Kirklees Highways Design Guide SPD , at point 3.18, states the following:

Looking at the applicant's submission, his design fails to meet this requirement.

| SITE PLAN 2                                                                                                           |          |            |  |

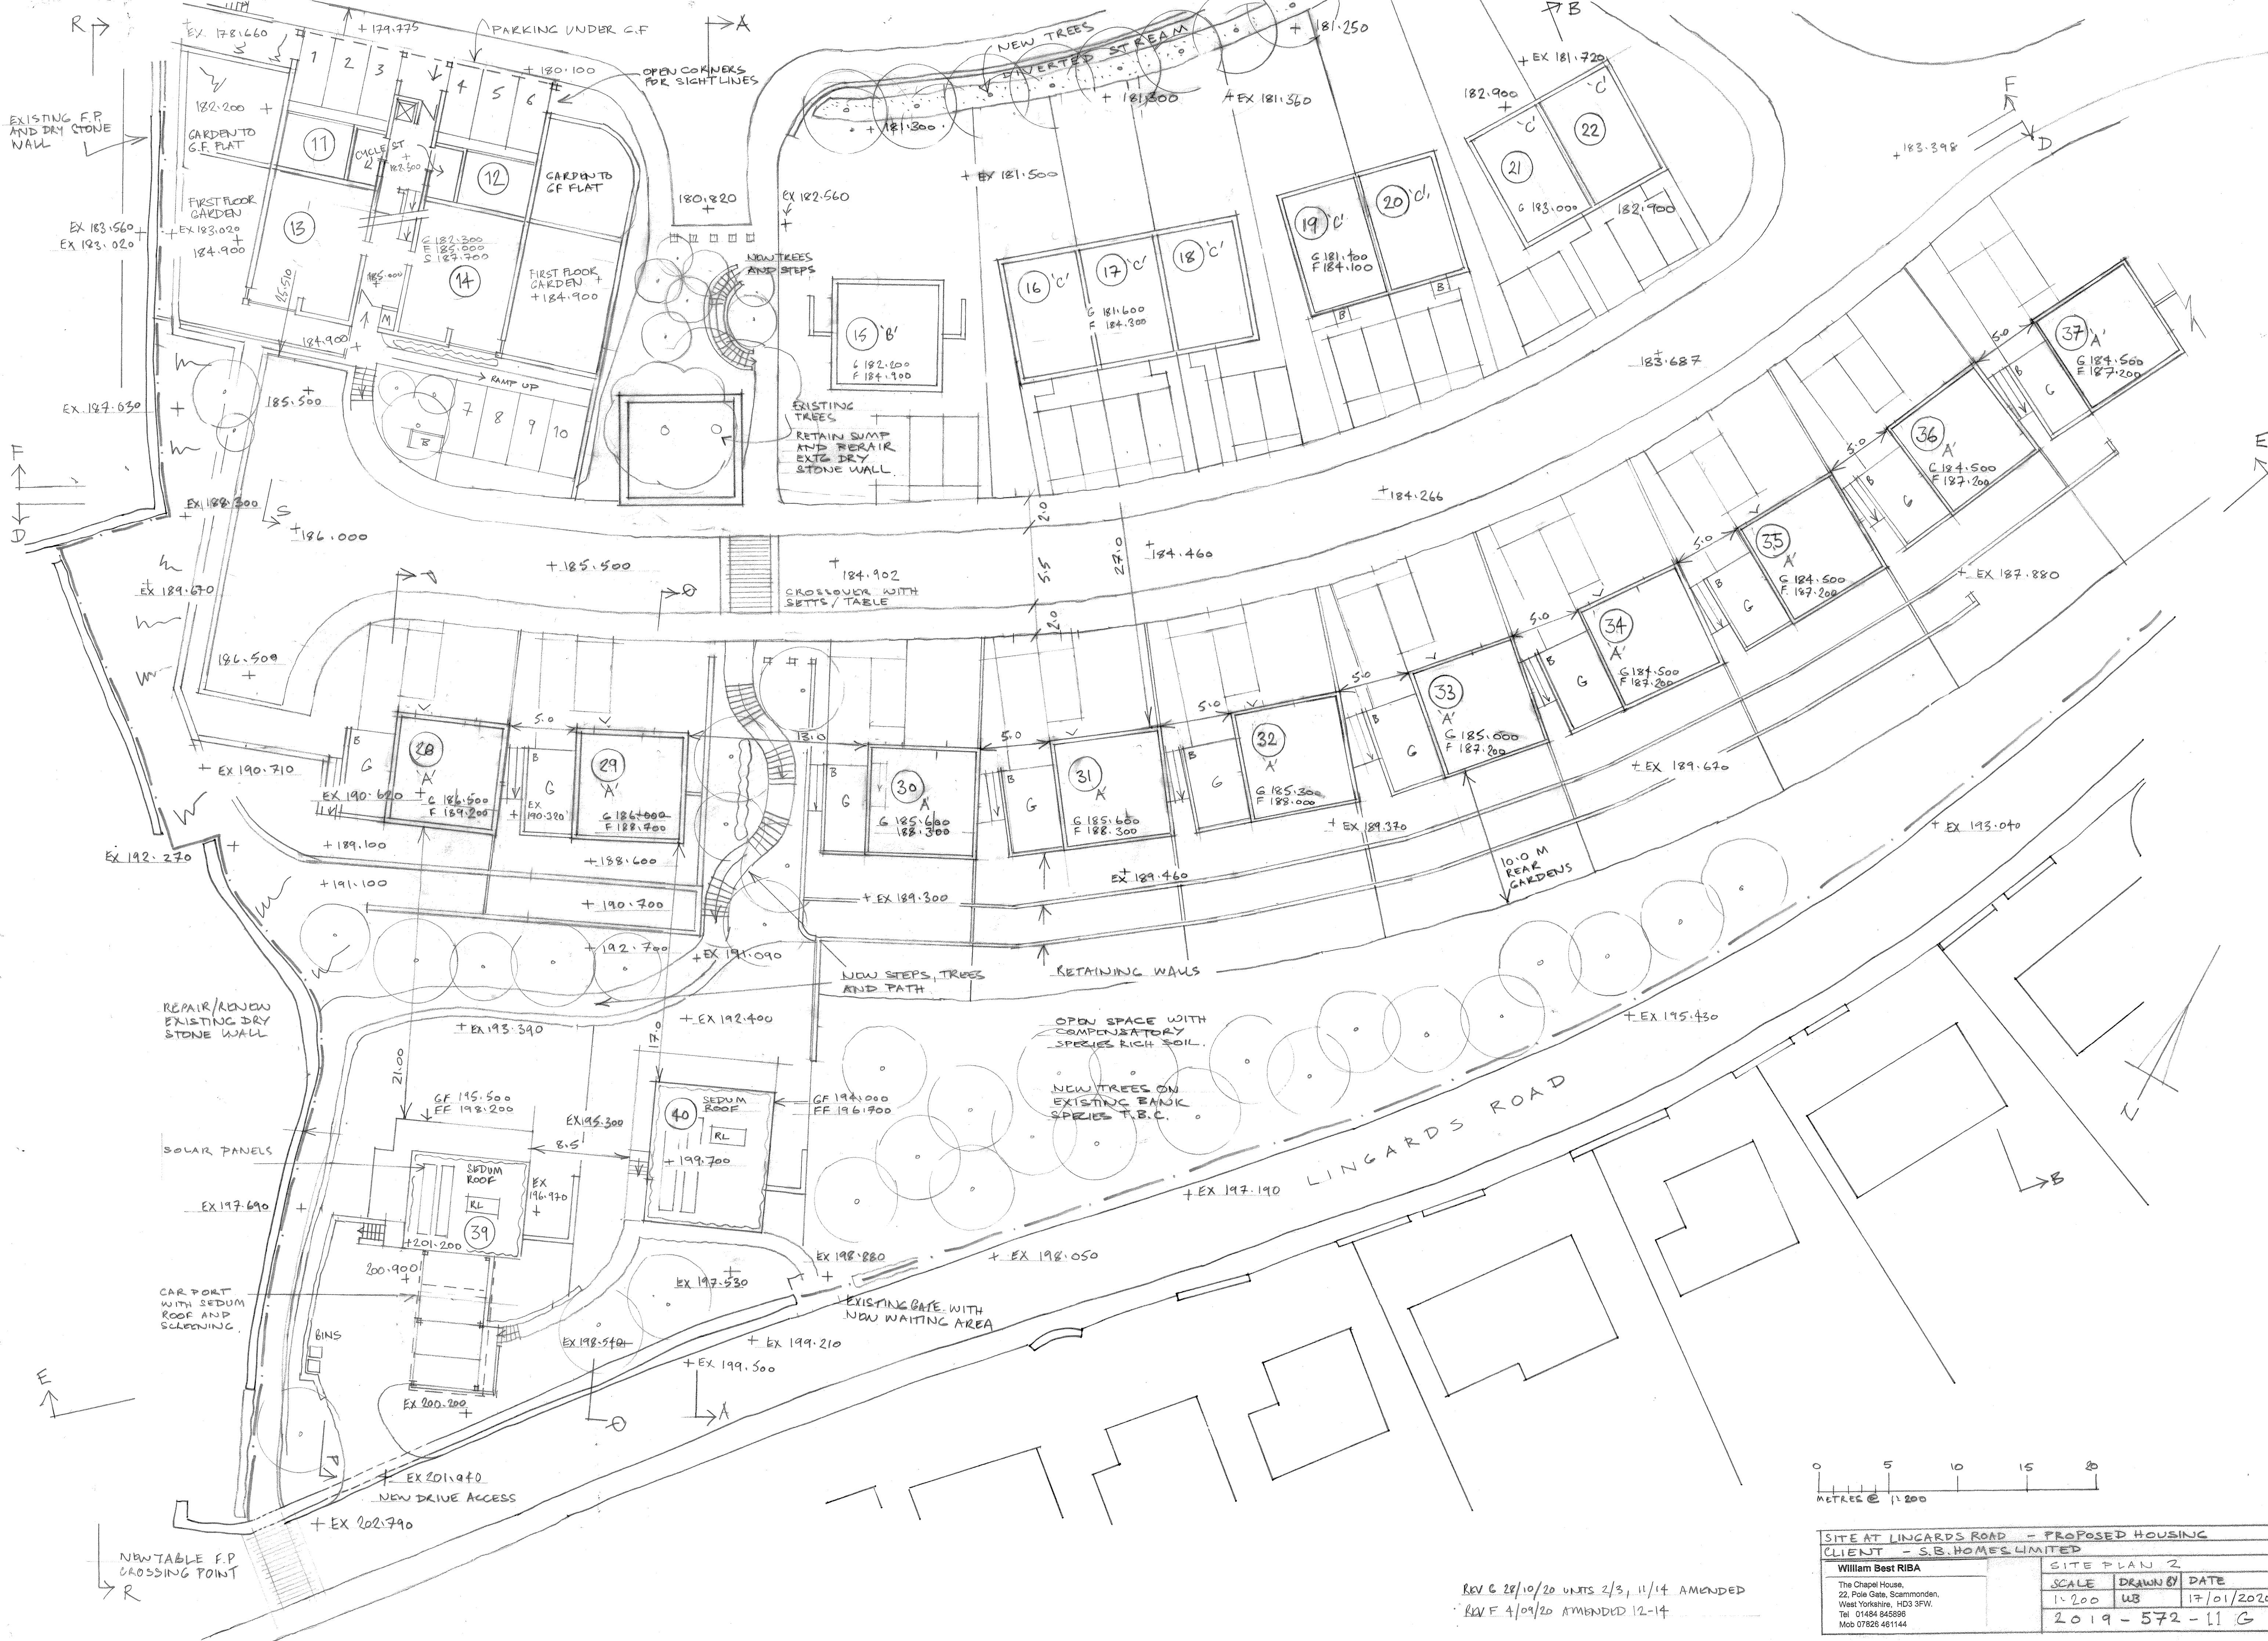
Of the ten dwellings he proposes would have direct access off Lingards Road, only one has a drive that meets this requirement (plot 42).

The following shows the plots and their respective drive widths:

Along the initial side of each drive, there are structures (e.g. walls and/or gate posts), meaning the drives should be 5.0m wide.

This is because these structures would seriously hamper residents trying to turn into and out of their drives.

This would be worse for proposed properties with shared drives, as drivers would (most likely) not know the whereabouts/movements of the neighbours vehicles; increasing the potential risk of accidents at drive entrances.

Please note, as well as gate posts, plots 38/39 have walls less than 5.0m apart, within the initial part of their drive.

If the applicant's design fails to meet the minimum local authority's requirements, the application should be refused planning permission.

*'To ensure that residents can access their properties, a private drive serving five dwellings or fewer should be a minimum of 4.5m wide (5.0m wide if there are structures along its initial length for example walls) for the first 5.0m of its length. This will allow vehicles to turn in and turn out.'*
